**FFERM WYNT ALLTRAETH MONA / PROPOSED MONA OFFSHORE WINDFARM
CYFEIRNOD YR AROLYGIAETH GYNLLUNIO / PLANNING INSPECTORATE
REFERECE: EN010137**

RE: NATURAL RESOURCES WALES' DEADLINE 5 SUBMISSION

1.1.1 Comments on Updated Environmental Statement: Volume 2, Chapter 5: Offshore Ornithology F03 [REP4-007: clean; REP4-008: tracked]

Figure 1.2: PVA output chart showing the black-legged kittiwake population size under the baseline and cumulative collision scenario. Dashed lines present the LCI and UCI of the population size

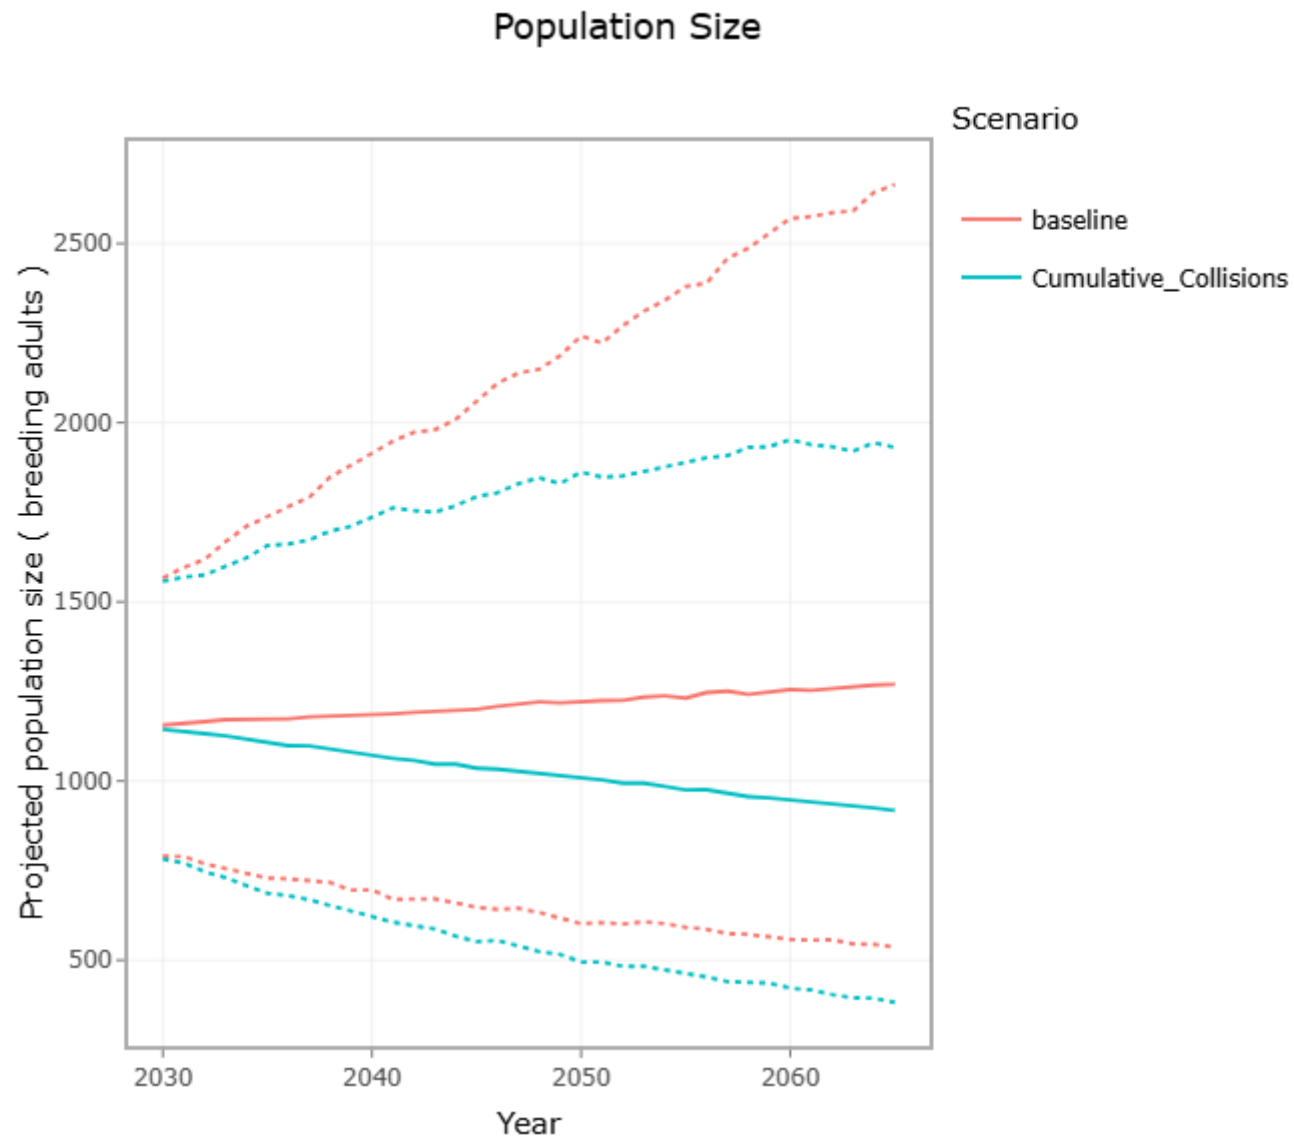
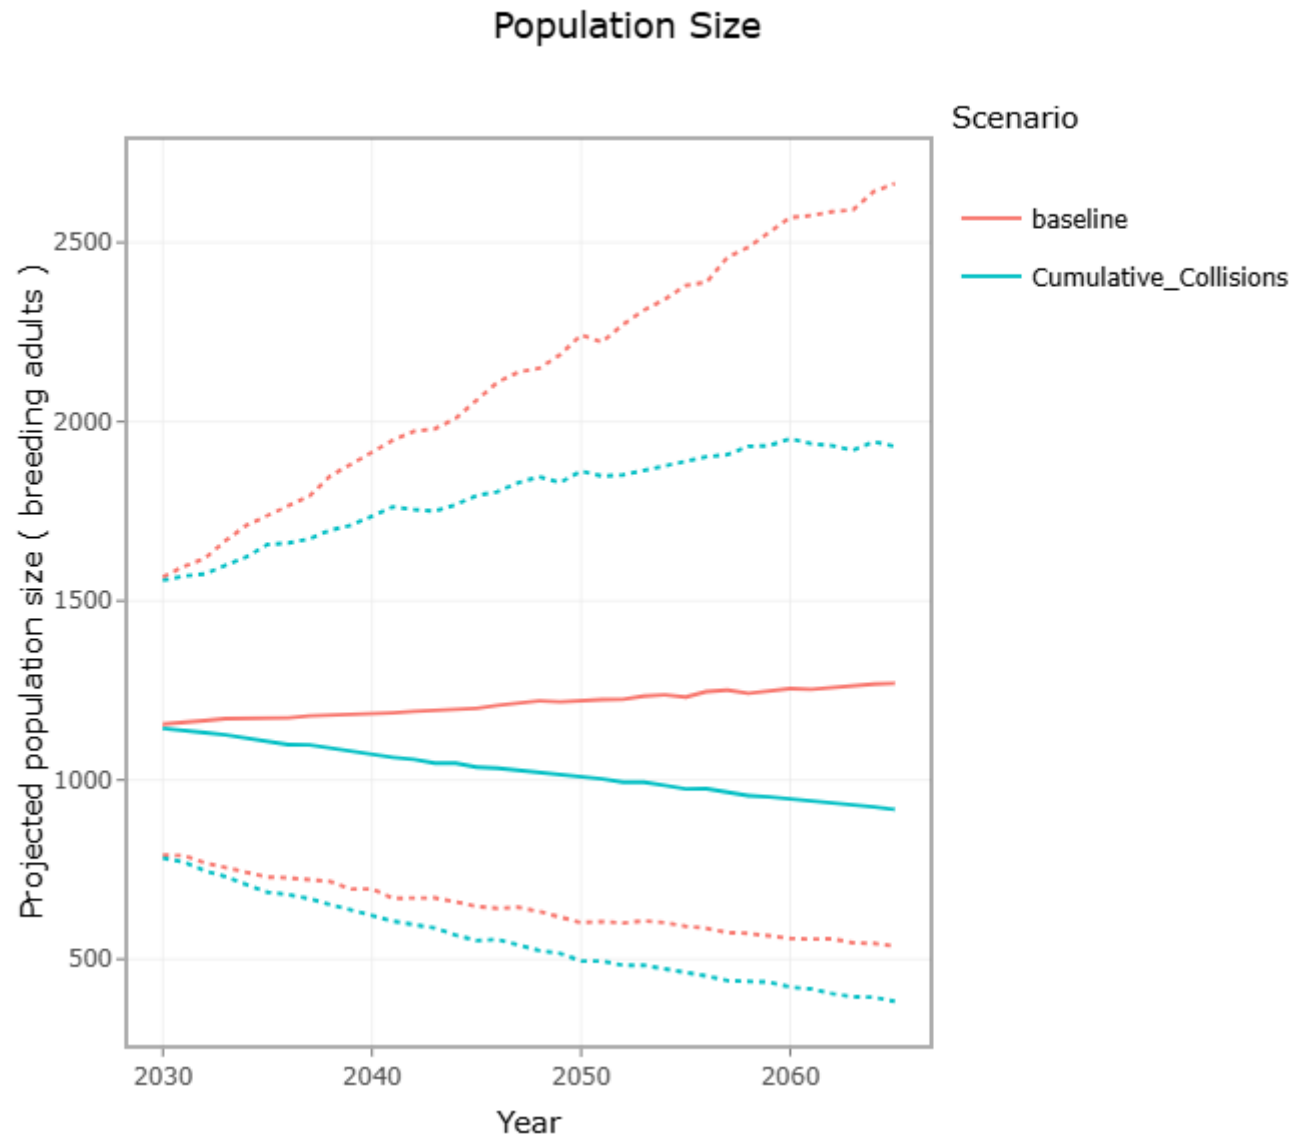
14. However, the kittiwake colony of the SSSI is decreasing, but not at a rate that has been seen at other UK kittiwake colonies. Based on this, and that the

Applicant's PVAs suggest that the population would remain stable due to the project alone impact and that the population would decline due to the cumulative impact, we consider that the predicted cumulative collision impacts as presented, which are likely to be underestimated, have the potential to give rise to a moderate adverse impact.
